Recommendation Report for Planning Permission

REF NO: K/54/20/PL

LOCATION: Land East Of Kingston House
Kingston Lane
Kingston
BN16 1RP

PROPOSAL: Single storey 4 bed dwelling & stable block (resubmission following K/16/19/PL. This application is a Departure from the Development Plan & is in CIL Zone 3 & is CIL Liable.

Client		Description	
		SITE PLAN & EXISTING TOPOGRAPHICAL

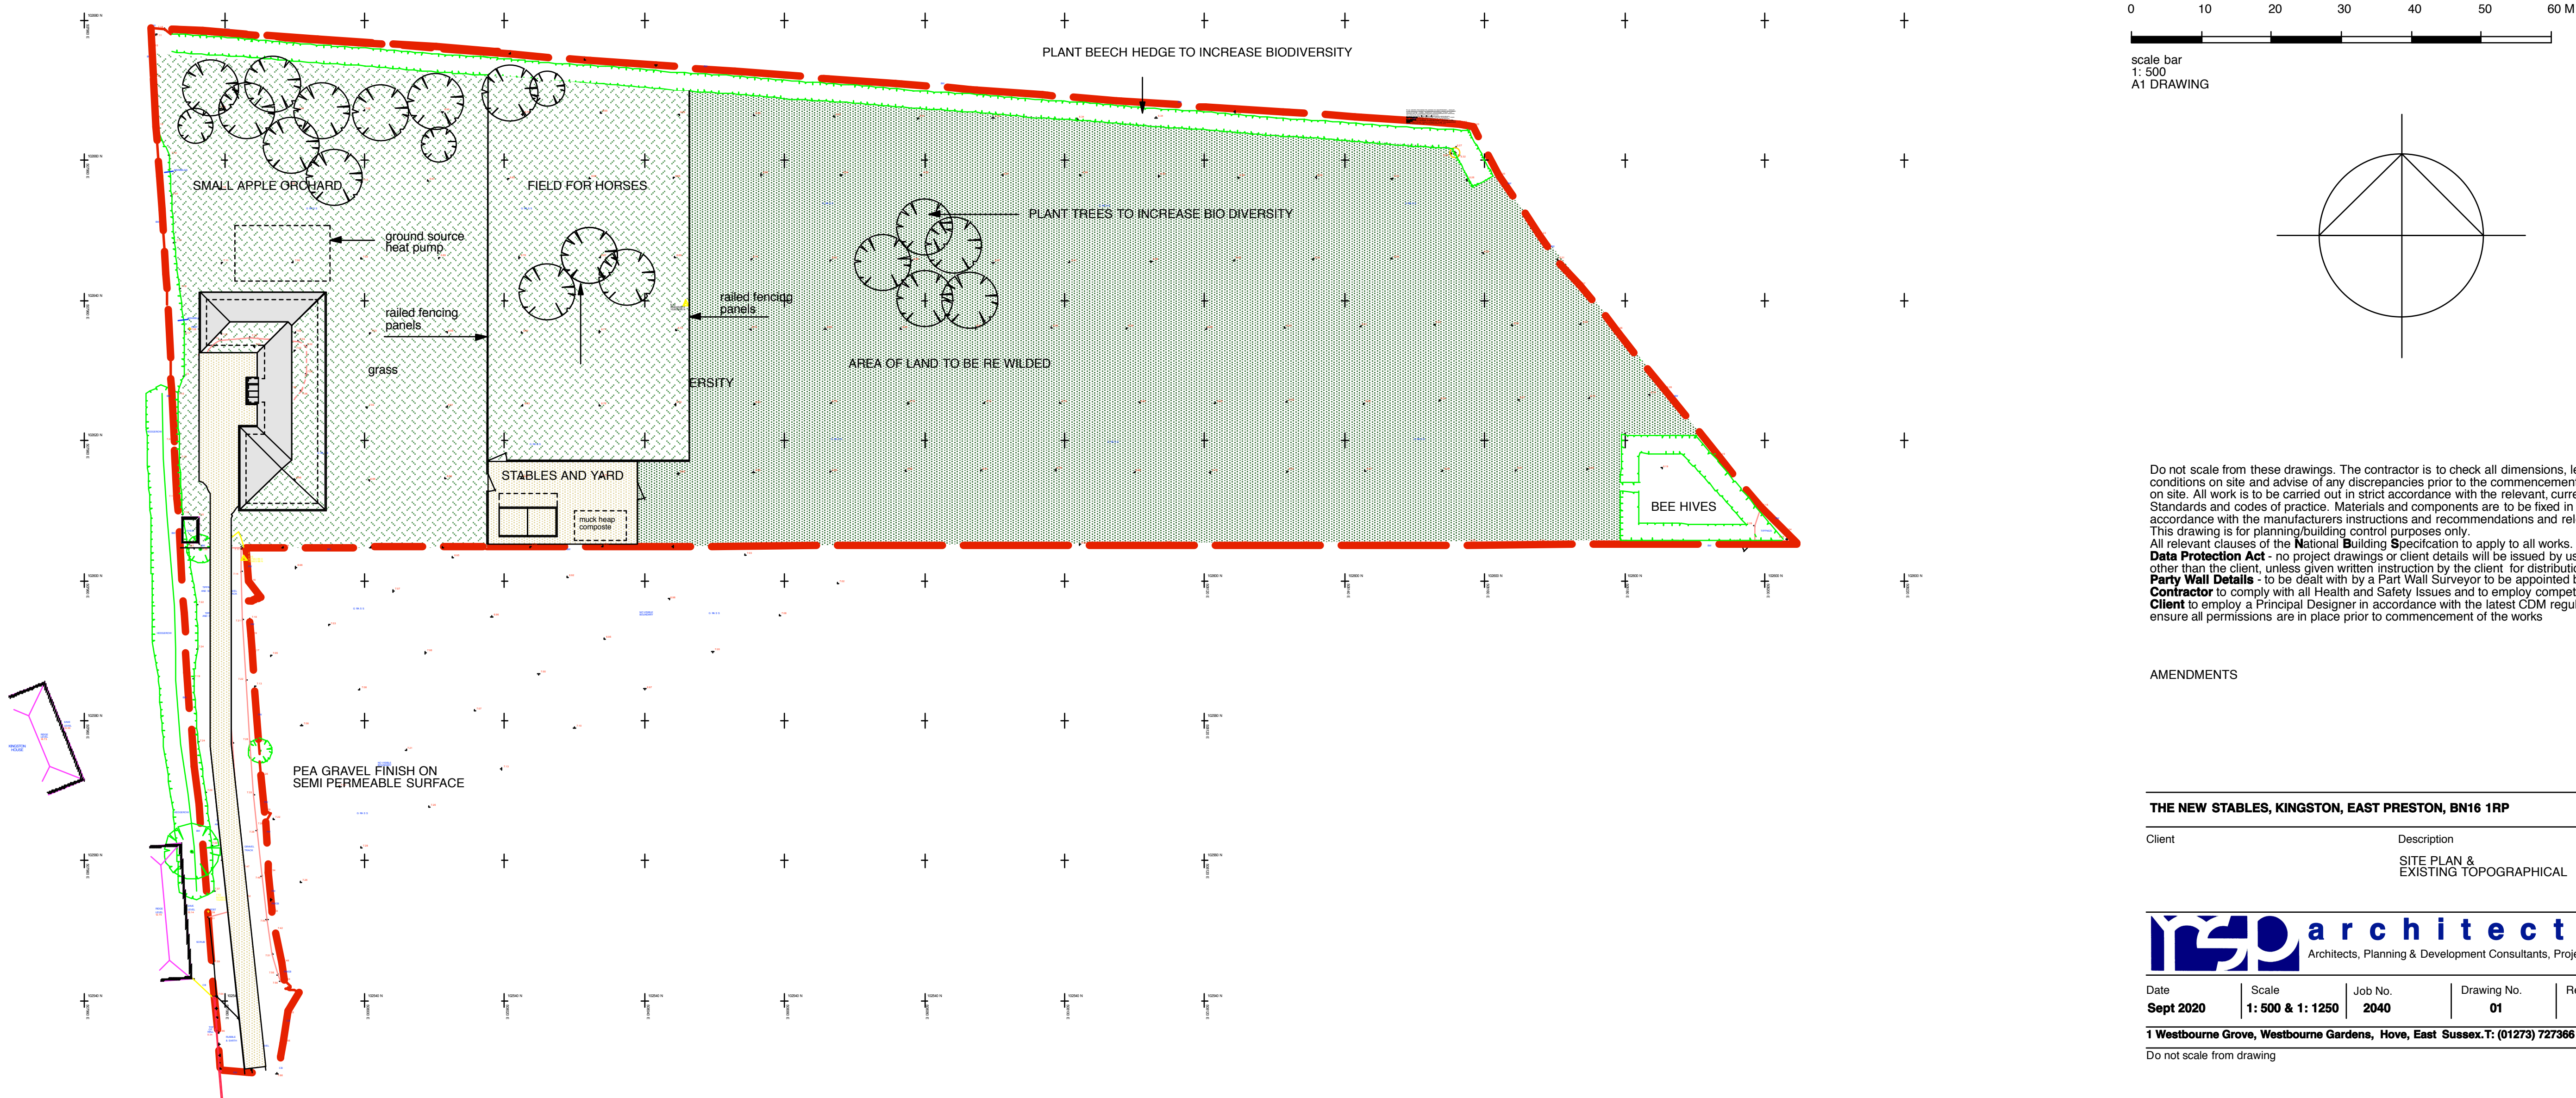
The proposed dwelling is considered to have a detrimentally harmful impact on the character of the locality. This is predominantly due to its siting, introducing a built form into a rural area, as the proposed dwelling edges further into the open fields surrounding the locality.

The proposed relocation (turning the original dwelling by 45 degrees) and the change of proposed materials are not considered to acceptably ameliorate the negative impact of the dwelling upon the character of the area. The proposal remains the same size and design, an ill-proportioned squat bungalow within an area of intrinsic open beauty. The proposal is considered to result in harm to the character of the area by way of the introduction of substantial built form within an open rural area. The proposal is not considered to respect or enhance the distinctive rural character of the area, in conflict with section Q.01 (Rural Development) of the Arun District Council Design Guide which seeks to integrate rural development into its setting.

The development is not found to be sensitively and appropriately integrated into its landscape setting which forms the dominant character of the location, in this case open and unobtrusive. Whilst screening by way of planting is proposed this will not mature for a long period making the dwelling visible and alien within the open landscape.
